DRB Project Number: PR-2025-020144 Hearing Date: **12-10-2025**

Project: 907 Montano Rd NW Agenda Item No: 3

#### **PR-2025-020144**

#### **PA-2025-00374 – SKETCH**

Plat of
Tract A,
Las Colonias Medical
Elena Gallegos Grant
Projected Section 32, Township 11 North, Range 3 East, N.M.P.M.
Albuquerque, Bernalillo County, New Mexico
October 2025

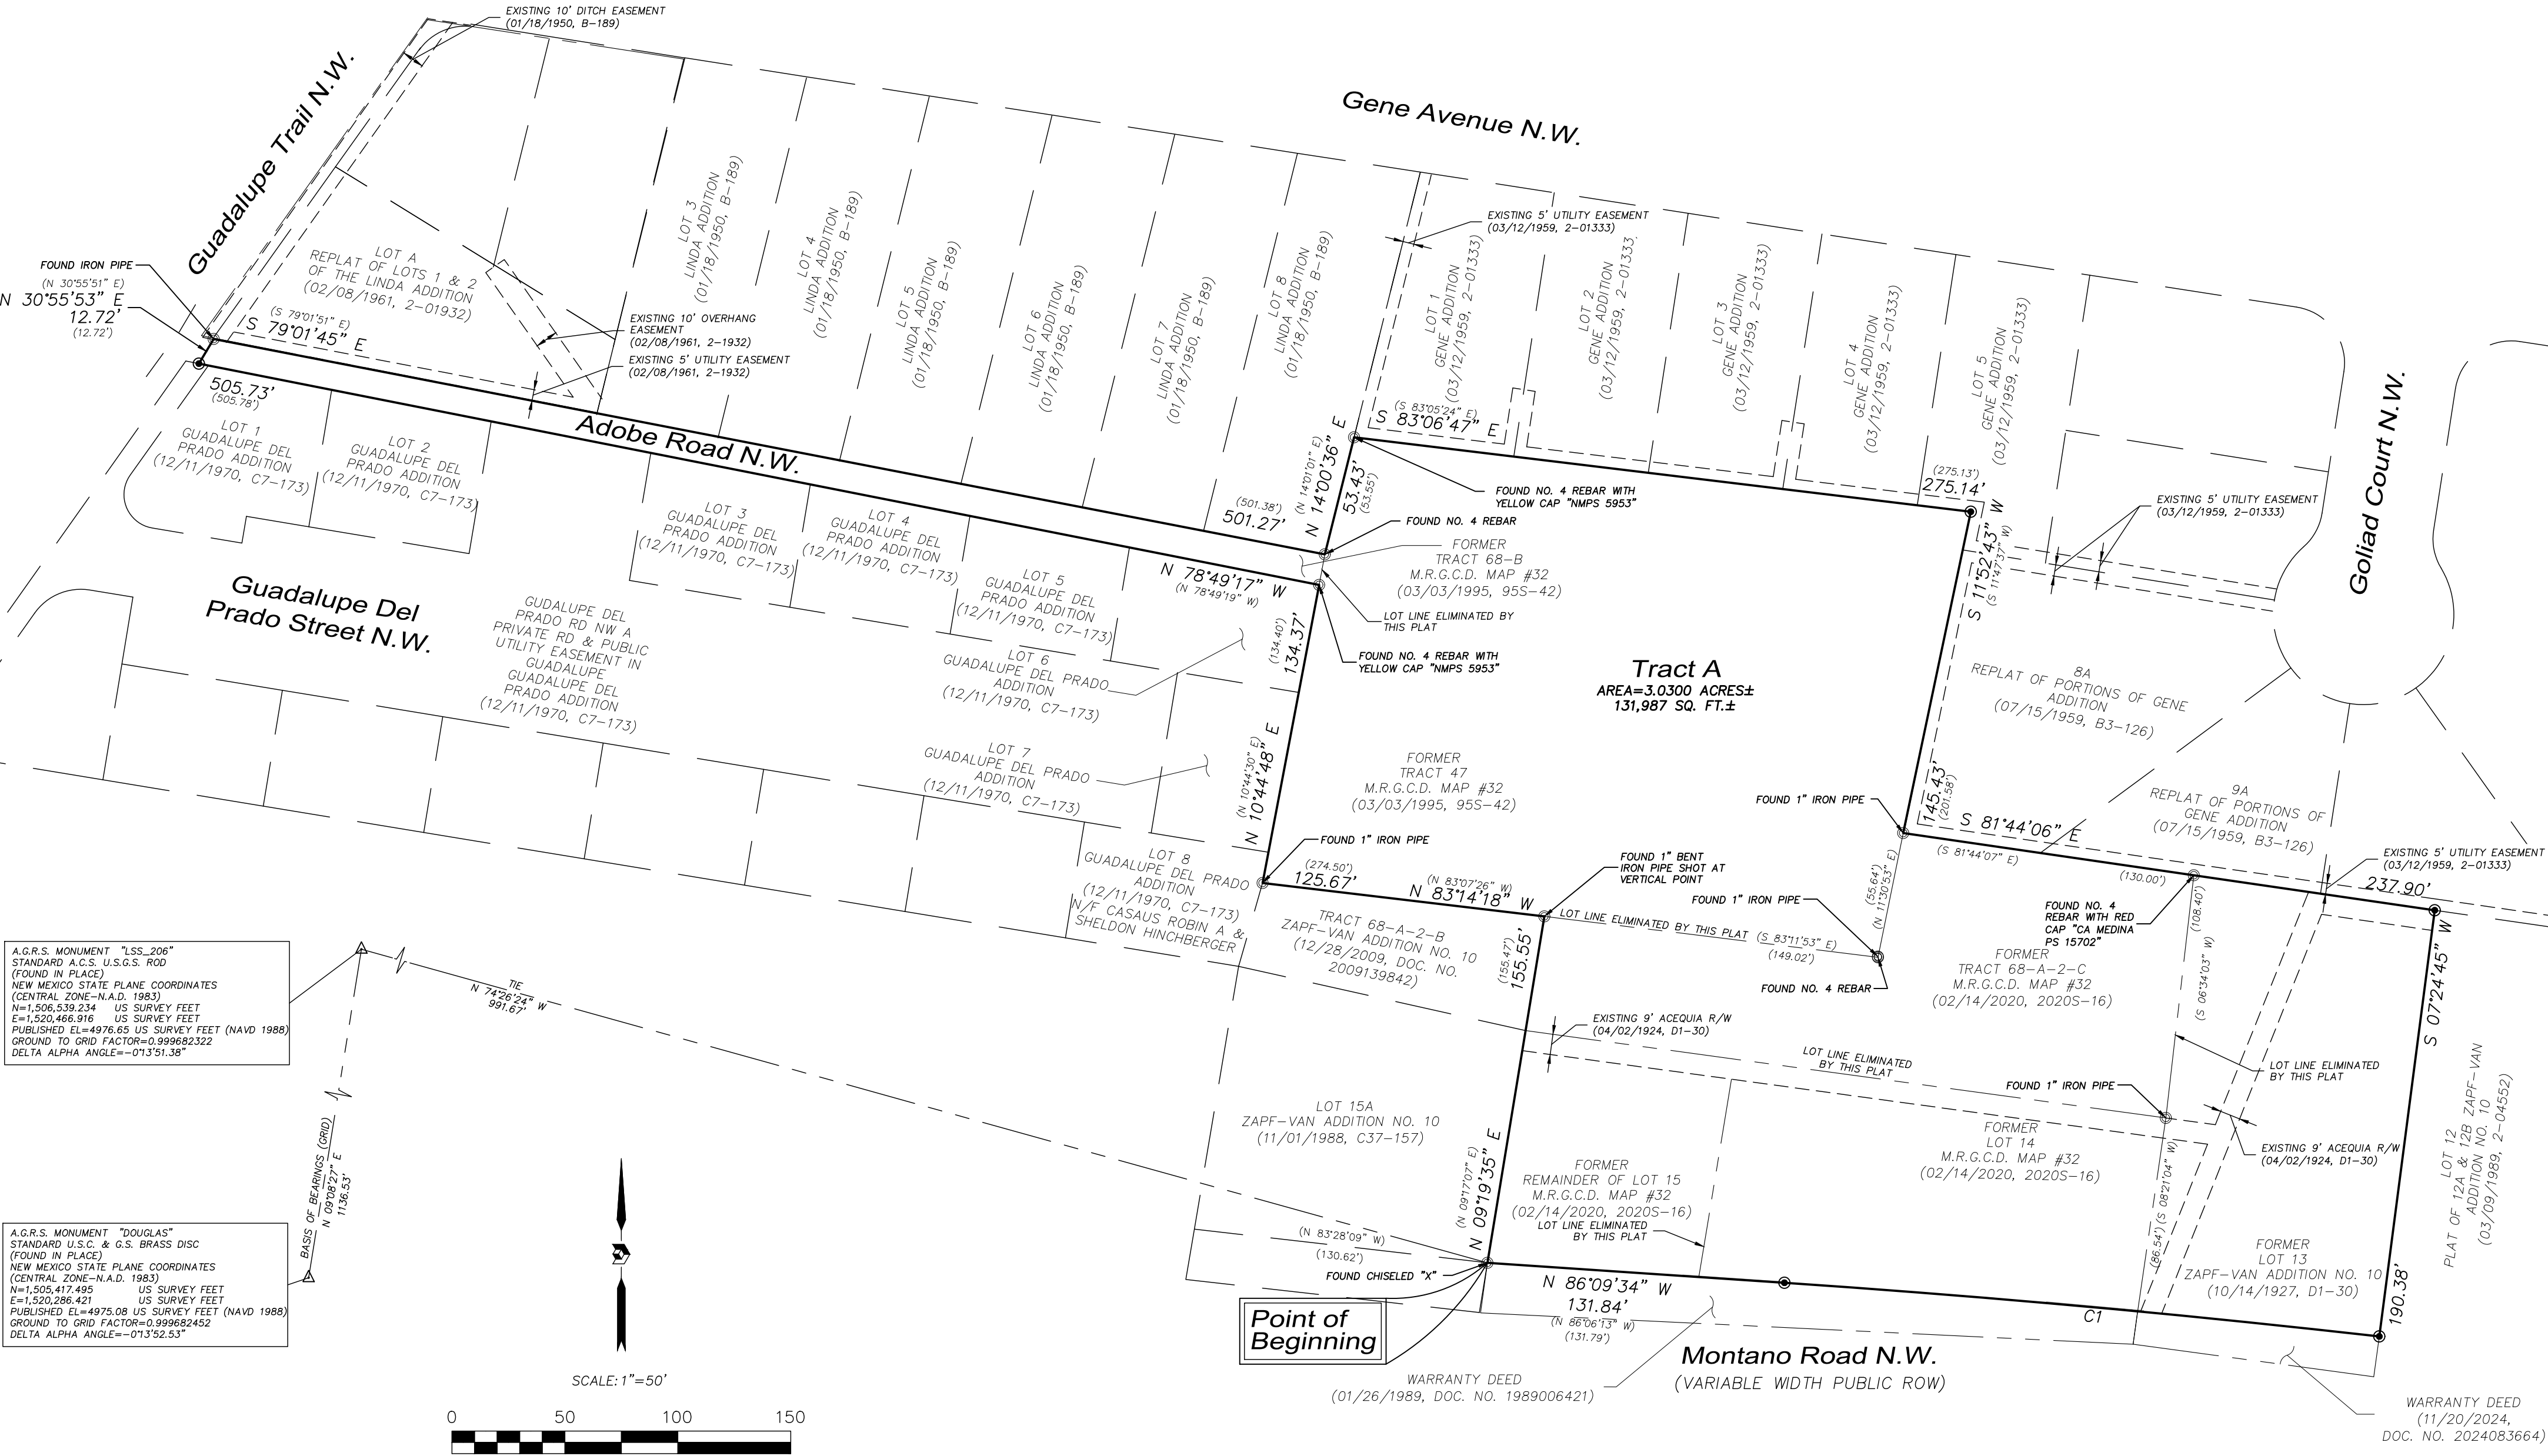
- 1- Montano is a principal arterial requires 6' sidewalk and 5'-6' Landscaping Buffer. Sidewalk width is not shown on the drawing, it needs to be widened if it is less than 6'.
- 2- Any future development will require an approved TCL prior to site plan or building permit. Also, a Traffic Scoping Form would need to be submitted to determine if a TIS would be required.

- There is an Acequia Right of Way (ROW) as well on the plat. Confirm if the acequia is active as well as if the ROW for the acequia will be affected by the proposed platting and/or future site development; MRGCD will need to sign a future plat due to the presence of the acequia on the subject property.

**Correct the Purpose of Plat to depict the legal lots that are being consolidated to create the Plat.**

**Similarly, the title of the Plat needs to depict what Tract A is being created from.**

**Lot 68A2C shows as a whole City lot in AGIS. Proof of deeded boundary line required.**
